Application for Listed Building Consent to redecorate exterior & replace existing
signwork & lighting with new
Swan Hotel 27 High Street Arundel

Thank you for your internet representation made on 20th July 2012 which has been recorded
as **an objection** with the comments as follows:

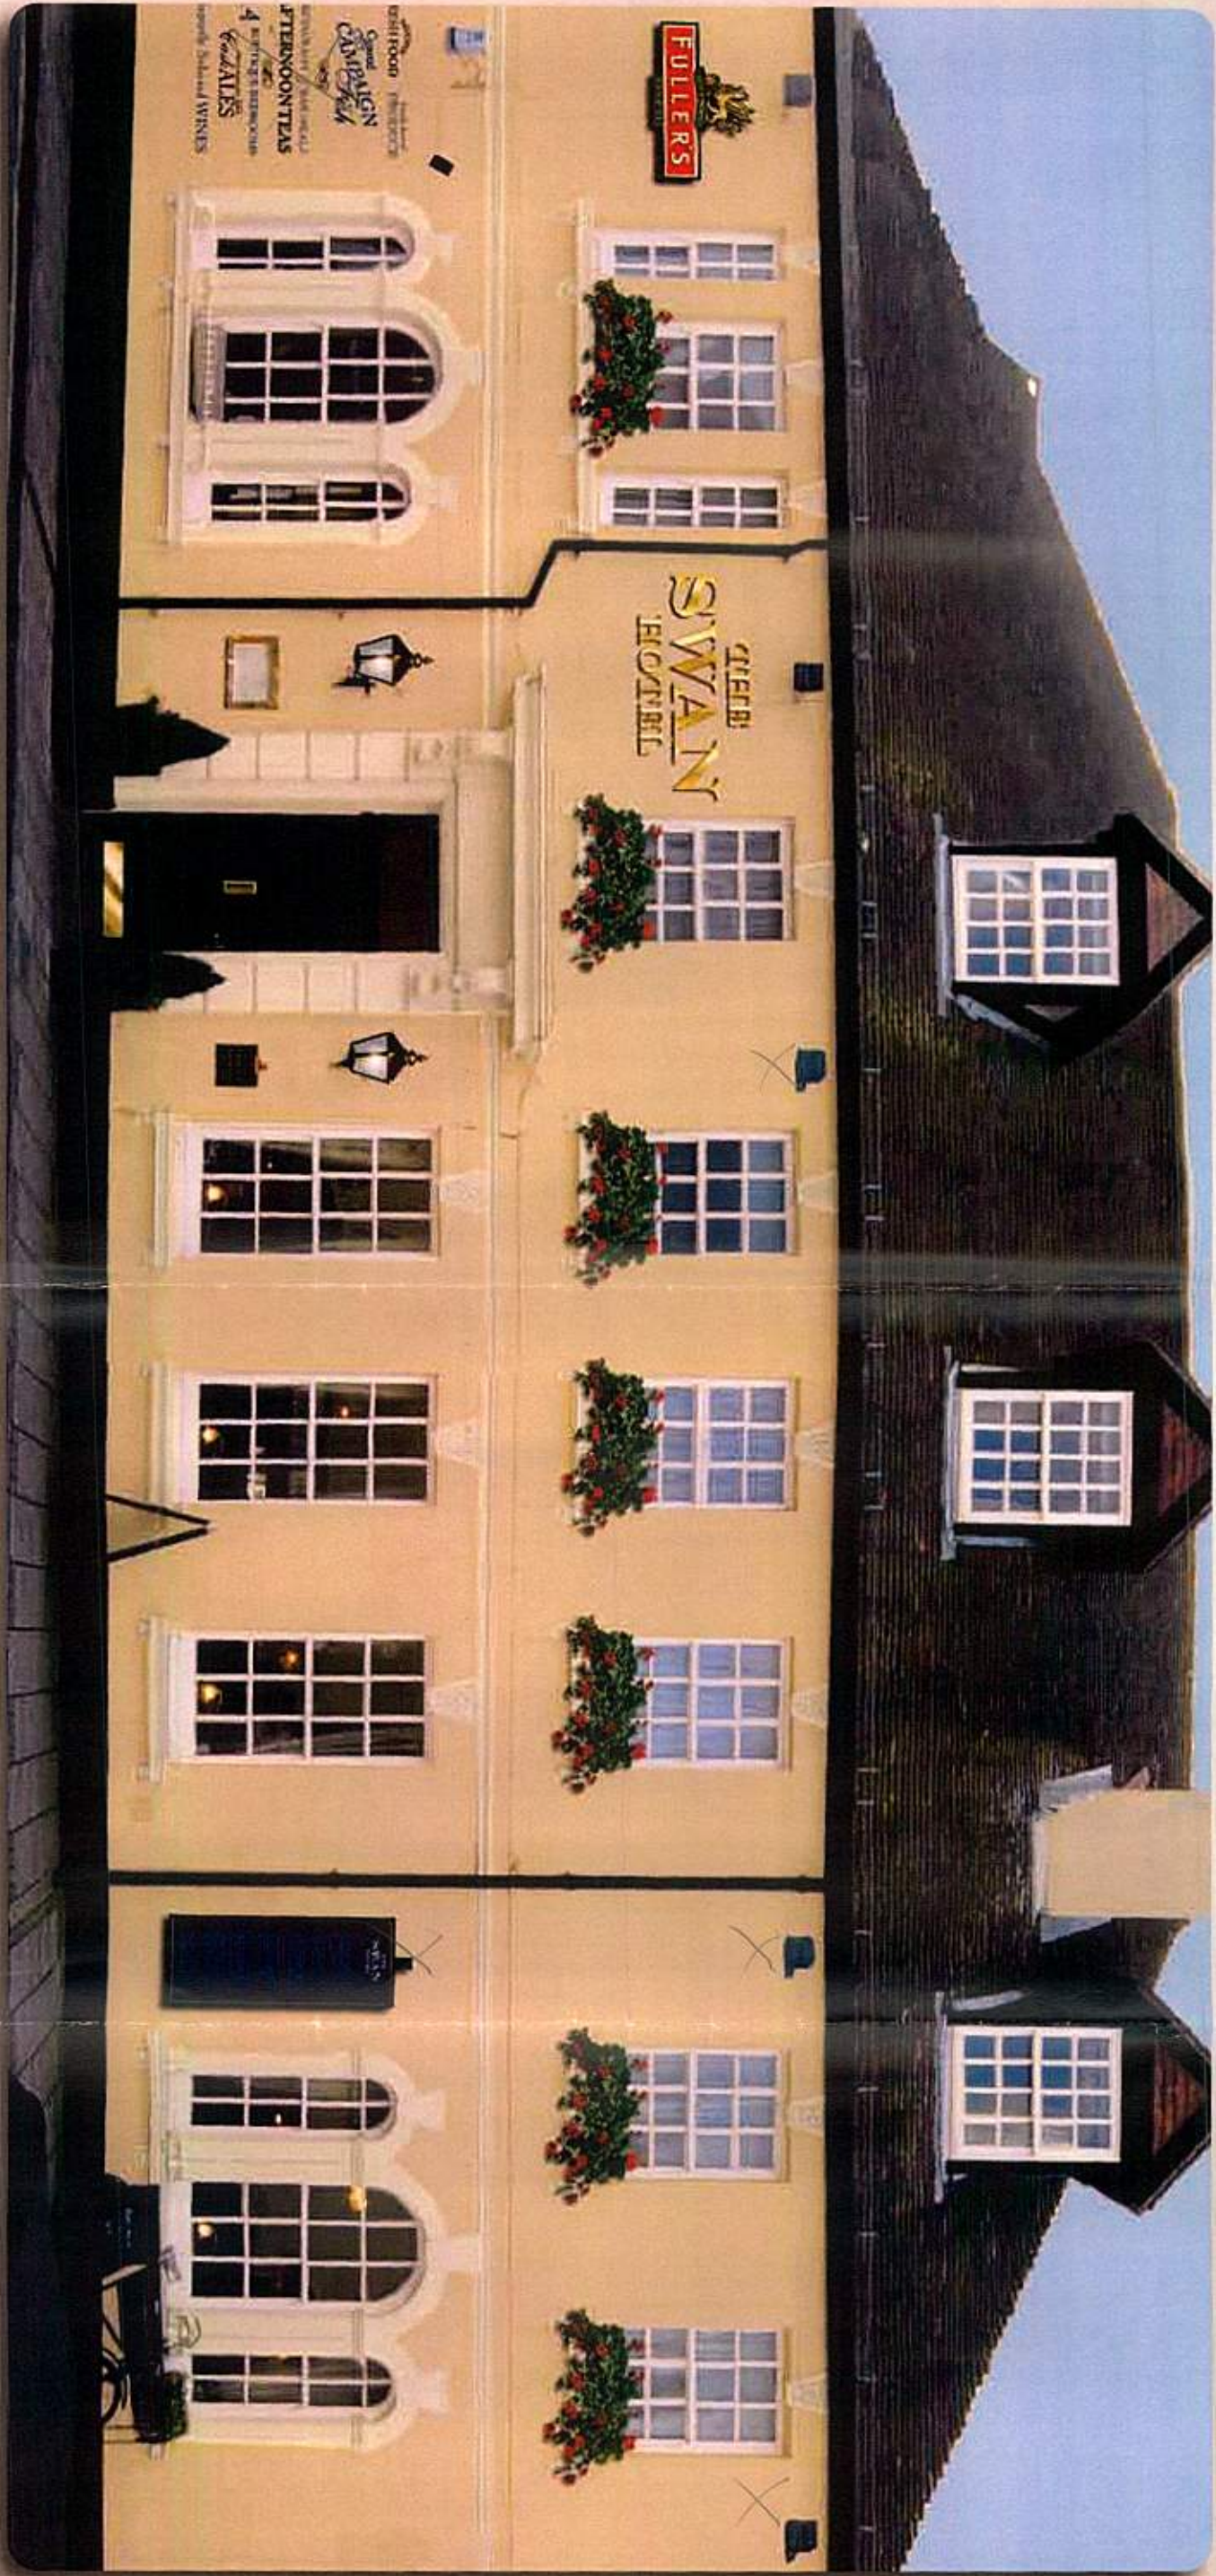
The Committee object to the signwork at ground floor level on the grounds that it results in an unnecessary proliferation of signage which harmfully detracts from an important, elegant and prominently located listed building.. Furthermore, if permitted, it could lead to other similar applications which, if allowed, could harmfully detract from the historic character and appearance of the Arundel Conservations Area. Without such signage the additional lighting is therefore unnecessary. The Committee would also comment that alteration works within the building appear to have been carried out without listed planning permission. □
